From: Simon Davis
Sent: 11 September 2017 15:26
To: 'Philip Pollard'
Subject: RE: Our Ref: PWP/nlg/14338 Aldingbourne Farm

RE: Discharged Conditions at Aldingbourne Farm

SCALE: 1:20

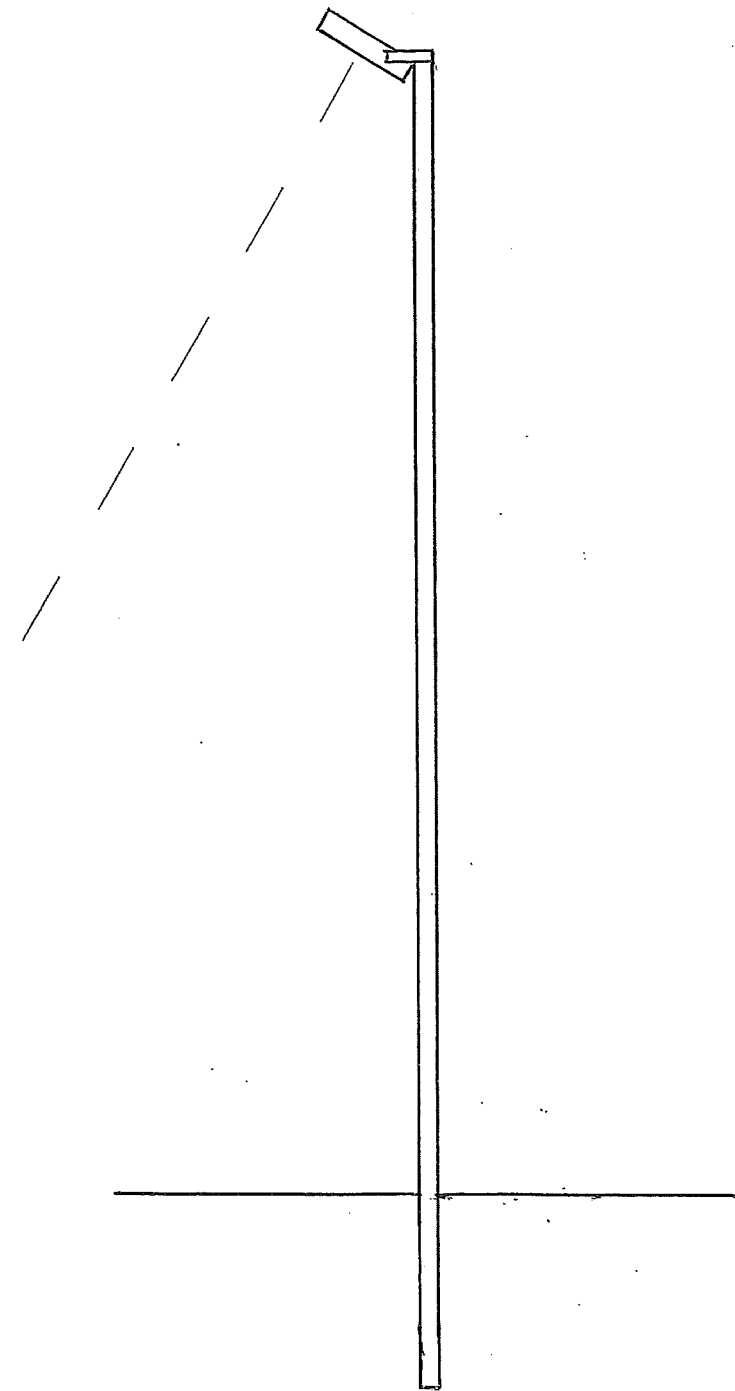
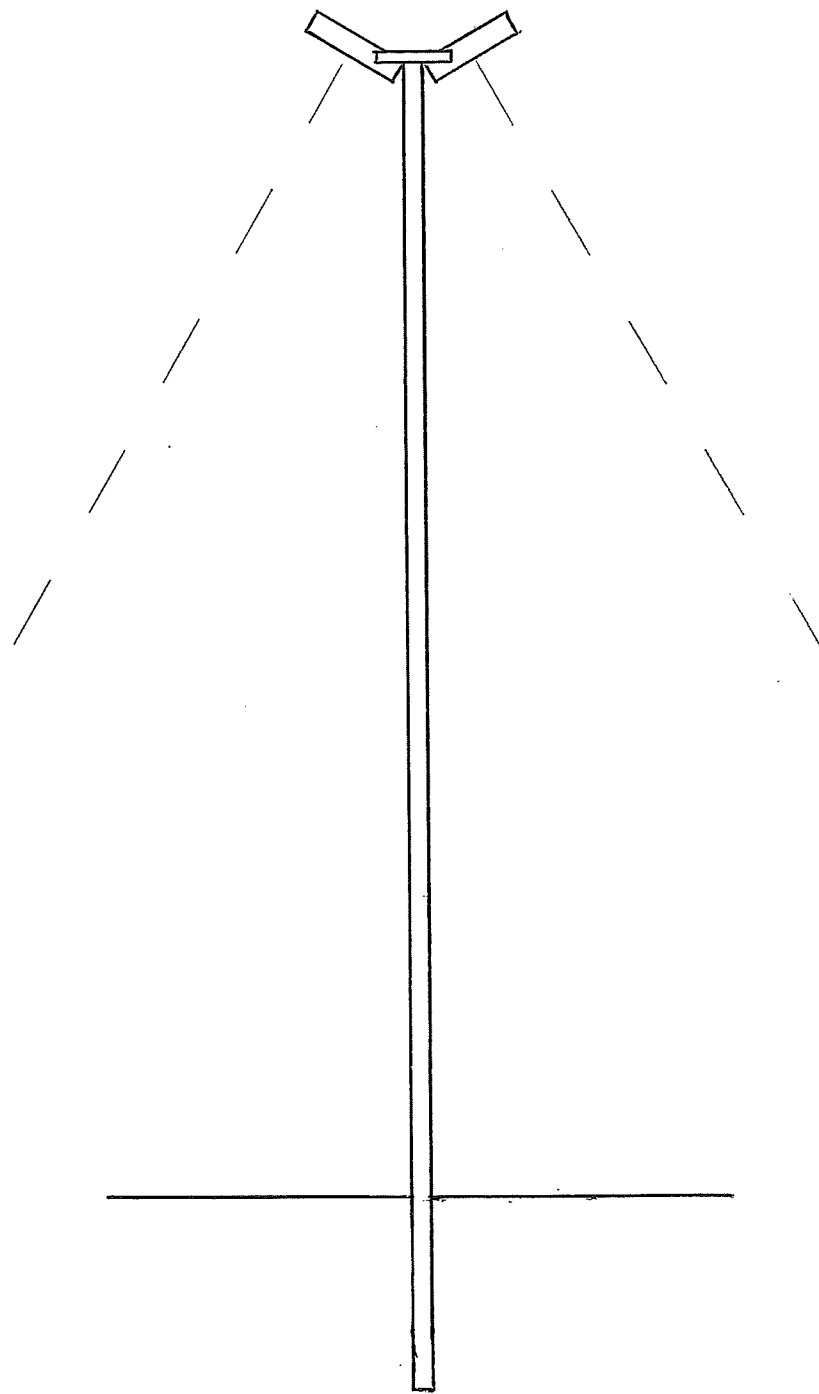
- (1) A simple scaled drawing of an example 3m light pole showing the light on top angled down.
- (2) A simple scaled drawing showing an example set of gates/gate with the light attached.

It would then be very useful if the lumens levels and the lighting times are marked on each plan.
